Ribble Valley Borough Council

App no: 25.0531

Address: Land rear of Pendle Street East Sabden BB7 9FX

Proposal: Proposed erection of single-storey dwelling house (self-build) within existing garden curtilage together with new access and hardstanding and demolition of garage.

Client: **MR & MRS WHITEHURST**  
 Project: **PROPOSED NEW BUILD BUNGALOW**  
**PENDLE STREET EAST, SABDEN**  
 Drawing Title: **PROPOSED SITE PLAN**

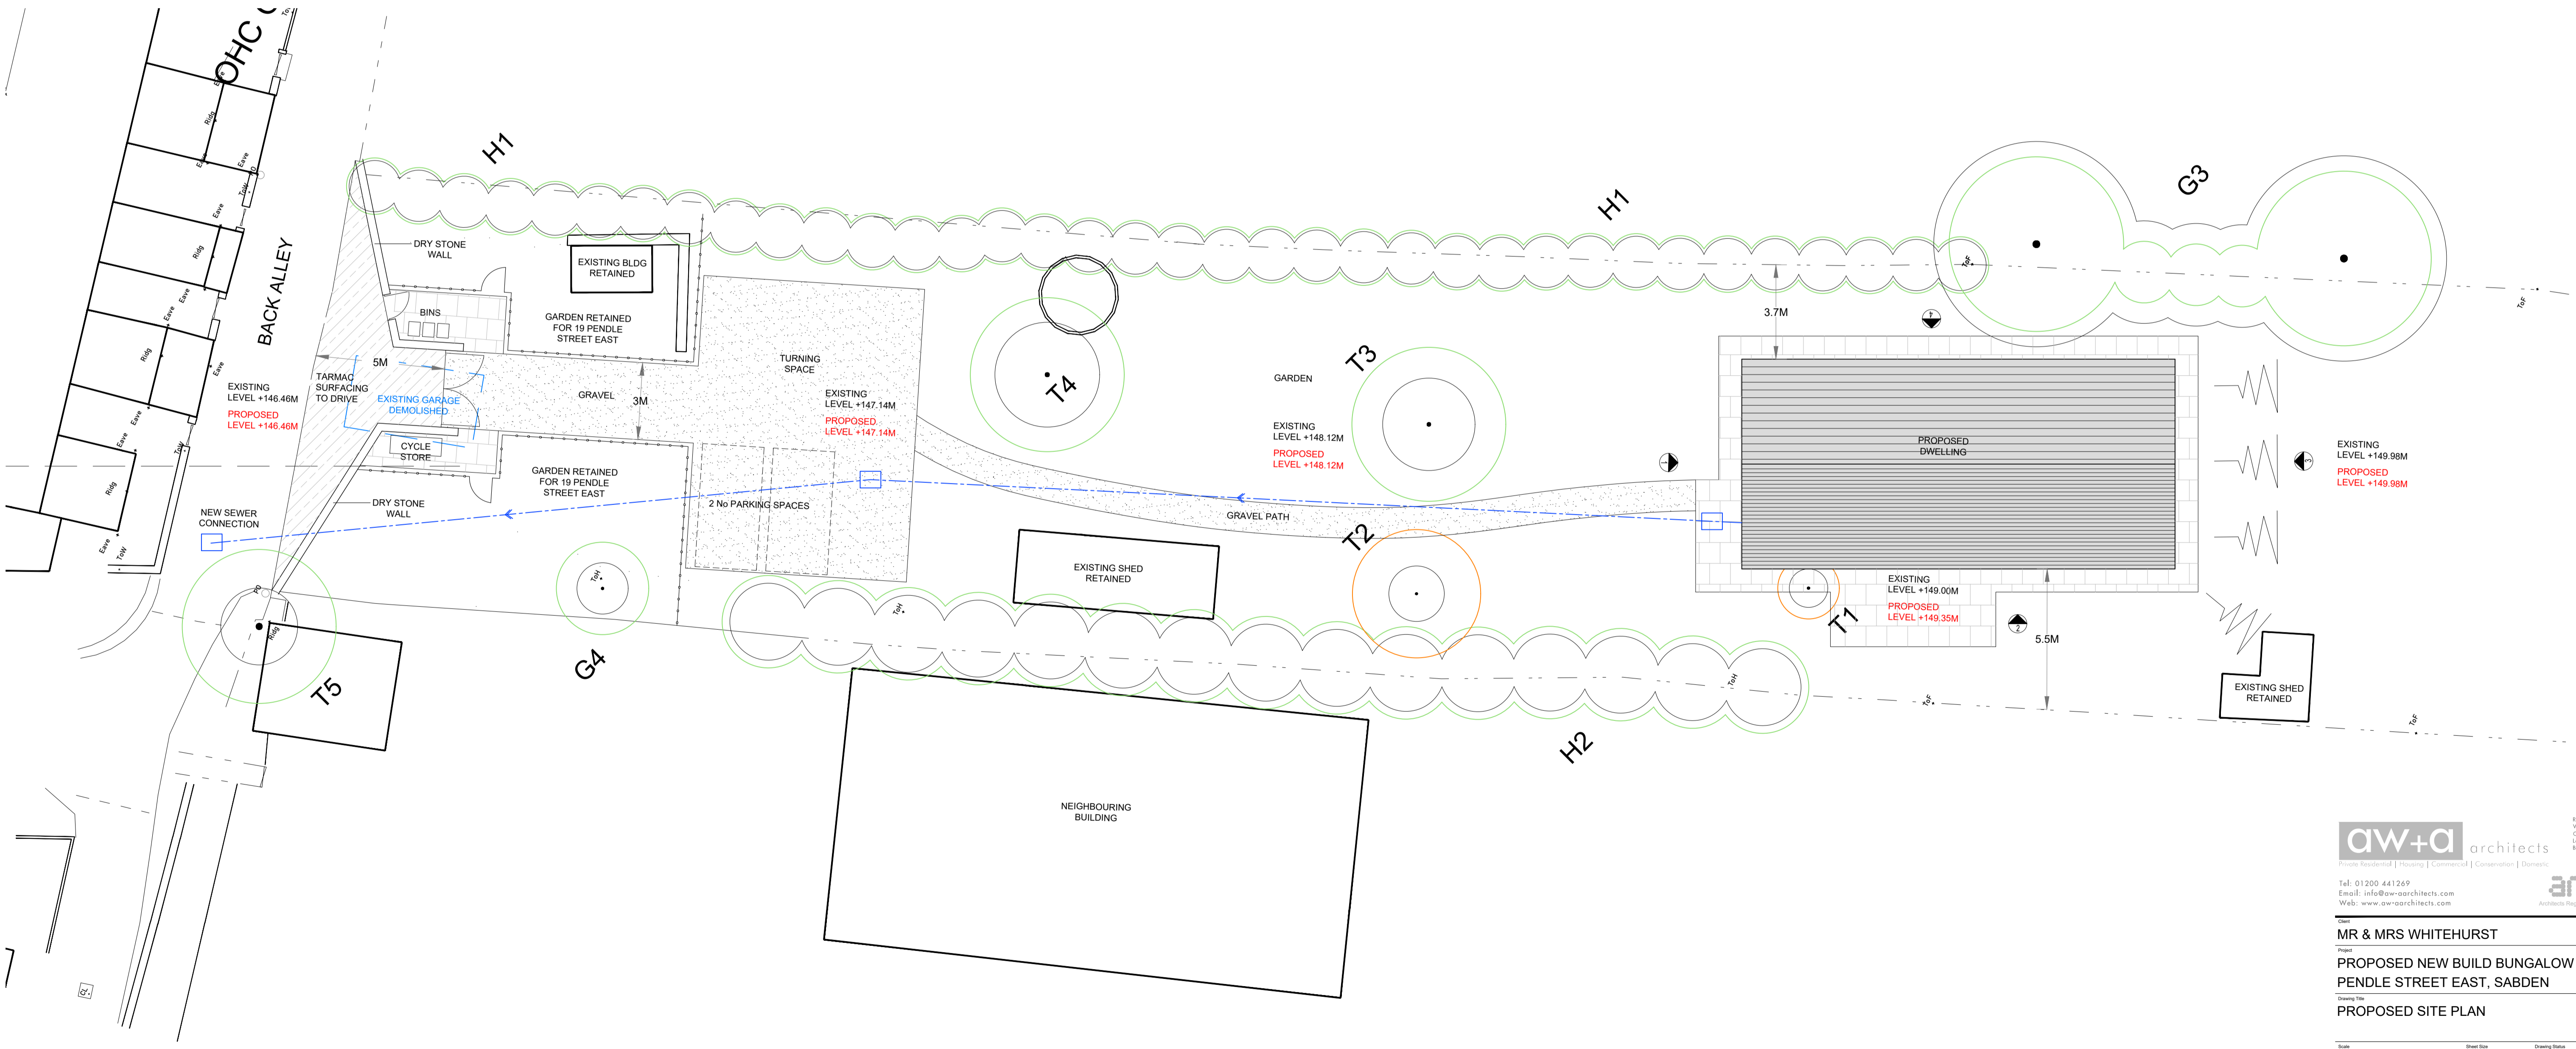
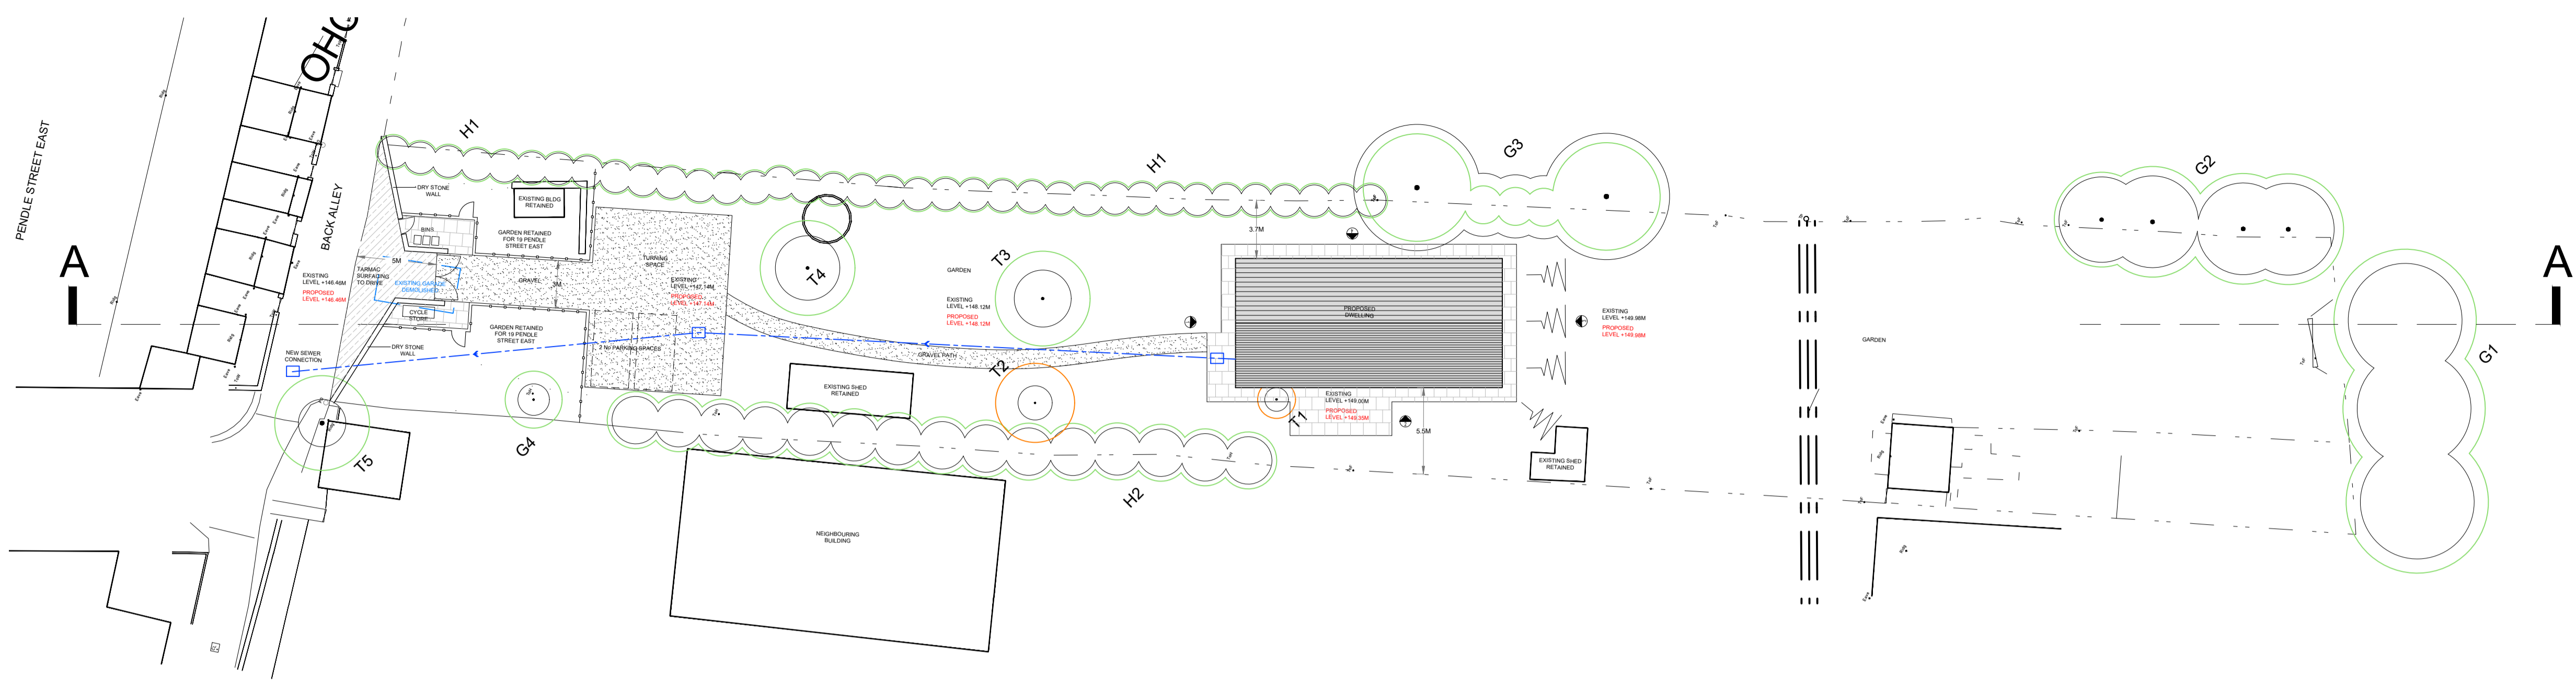
An existing garage will be demolished to create a new 3m wide access to the dwelling with the first 5m of the access paved in tarmac. The boundary walls are to be set back and splayed along the street to provide suitable visibility for the low speed and volume street environment.

There are 2 car parking spaces proposed within the site with space to turn and exit in forward gear. There is a secure cycle store which accords with the parking standards for a 2 bedroom dwelling.

2. Pre-commencement and post-completion photographic surveys shall be completed and submitted to the Local Planning Authority for the section of unmade street between Pendle Street east and the site access. Any damage caused during this period shall be repaired in conjunction with the Highway Authority and under an agreed timetable. Reason: For highway safety.
3. Prior to the first occupation the access driveway and parking area shall be constructed in a bound porous material and made available for use and maintained

for that purpose for as long as the development is occupied. Reason: To ensure adequate parking provision is provided.

4. Prior to the first occupation the secure cycle store shall be provided and maintained thereafter. Reason: To support sustainable travel.
